68 Deering St., BP#2014-02509

remaining questions:

FIRST FLOOR
68 DEERING ST

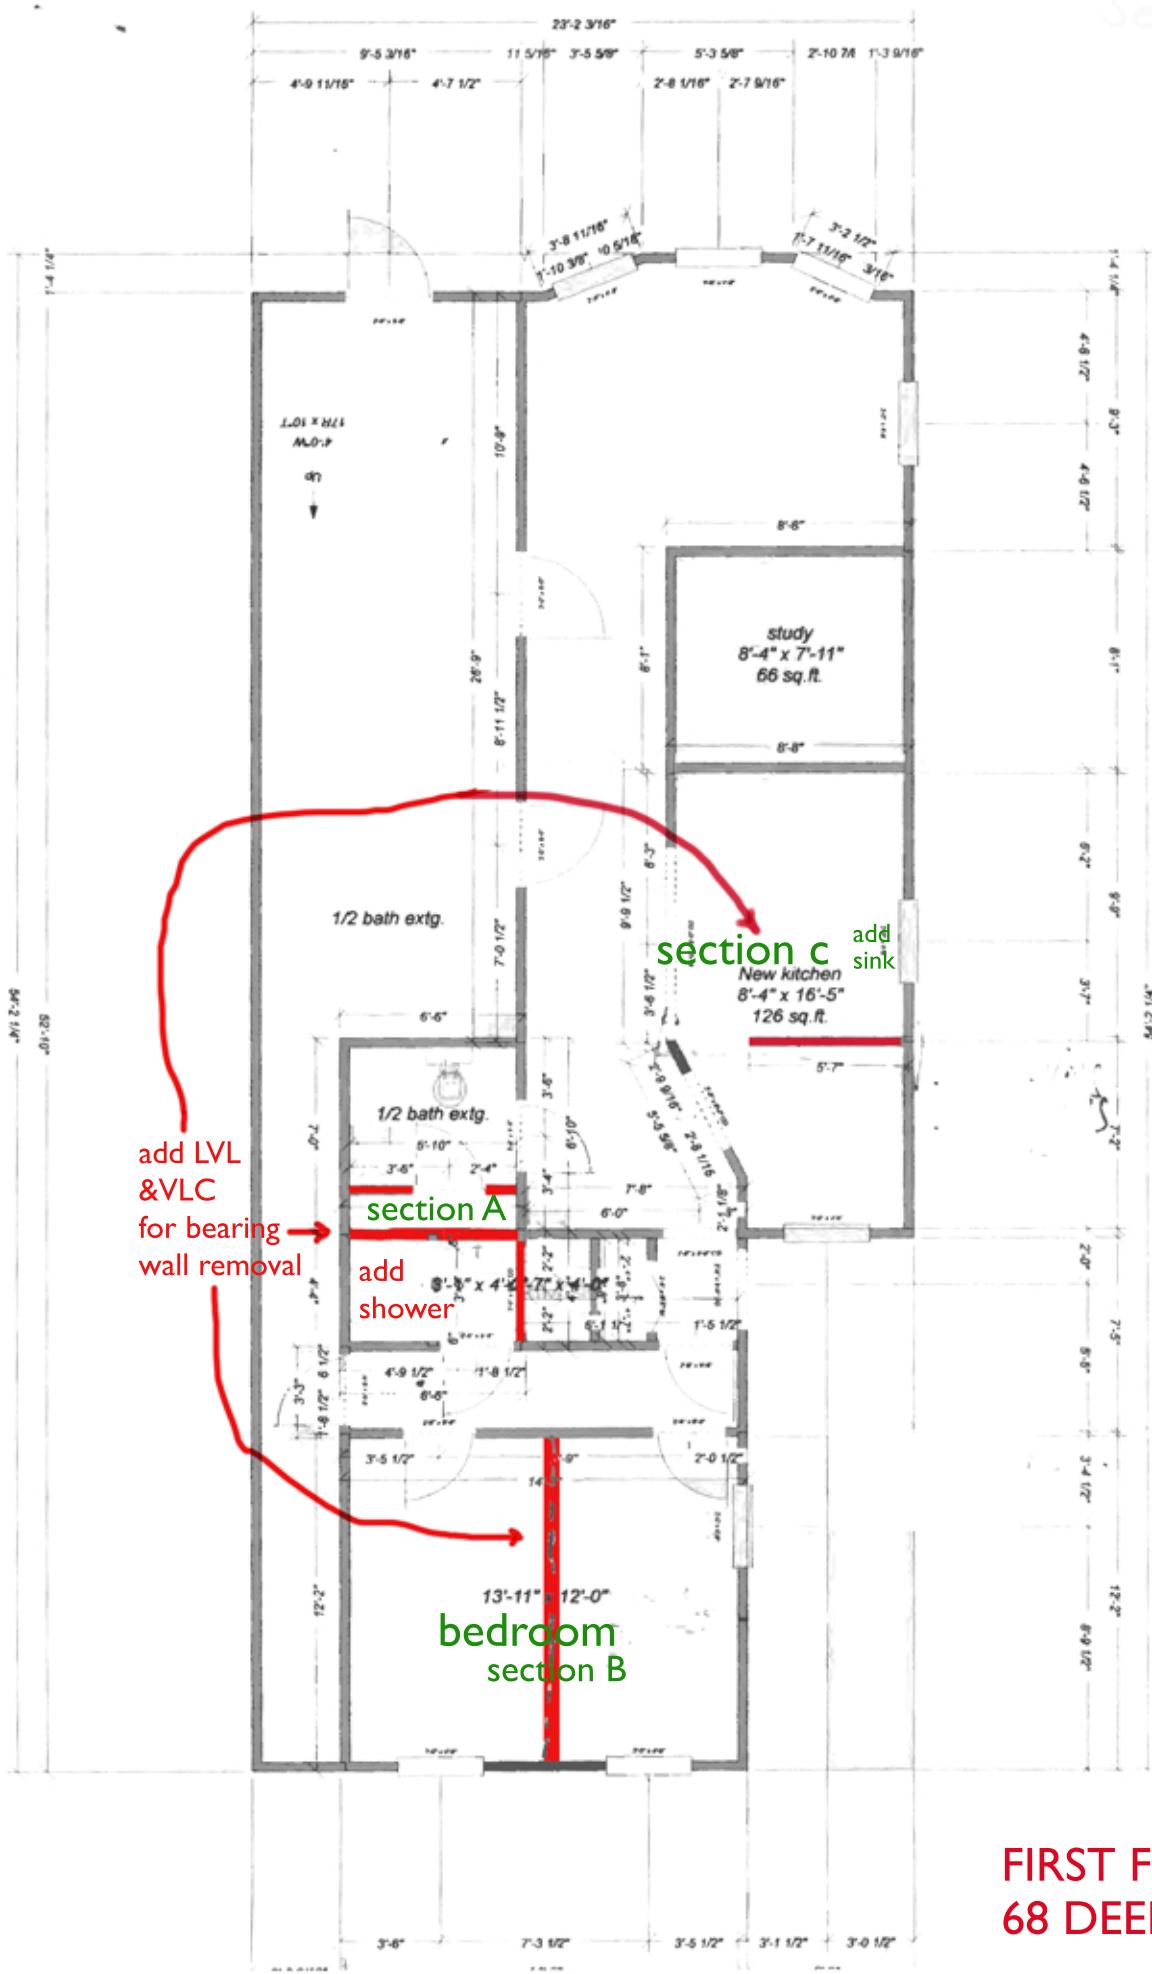
-Diagram of the load bearing path at all new Engineered beams, including any new footings and columns in the basement
Steel I-beam for 40" span in bathroom to solid brick wall. I beam carries the upper load with force paths going into the brick supporting the beam. The beam is supported by 6" of brick on either side.

On the first floor, **only the wall in the bathroom is weight bearing.**
